Attachment 1 – Request for Further Information

Easement for Stormwater Pipe

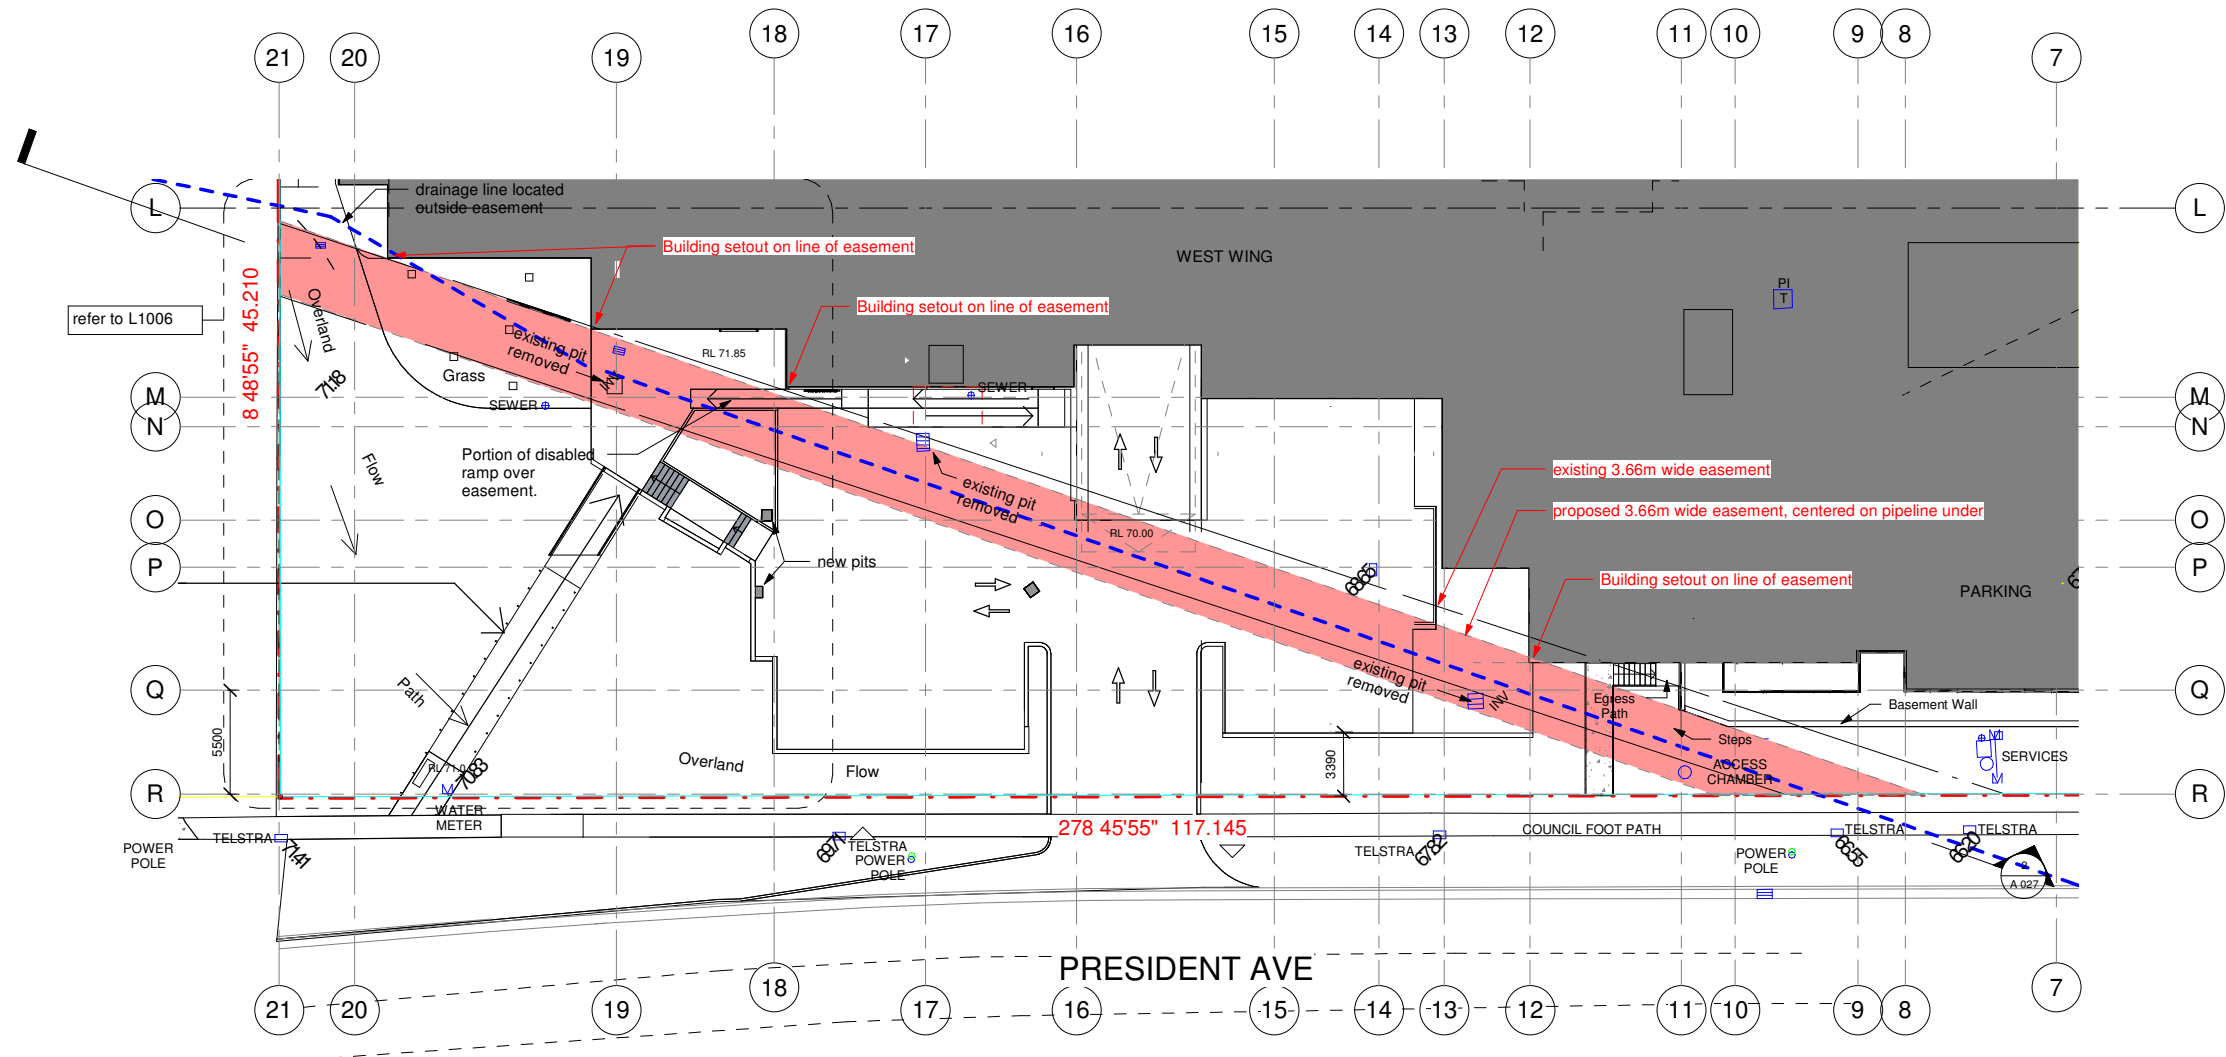
Easement proposal	Please show the proposed alignment of the realigned easement with respect to proposed and existing infrastructure.
General comments	<p>The main body of the RtS incorrectly states the number of submissions that have been made in relation to the project which are shown on the planning portal.</p> <ul style="list-style-type: none"> • 56 submissions • 54 individuals object • 2 individuals support • 1 public organisation • 6 public authorities
General comments	<p>Please review the Department guideline title Preparing a Submission Report which can be found on the following link; https://www.planningportal.nsw.gov.au/major-projects-reform Please update the format of the current report to align with these requirements.</p>
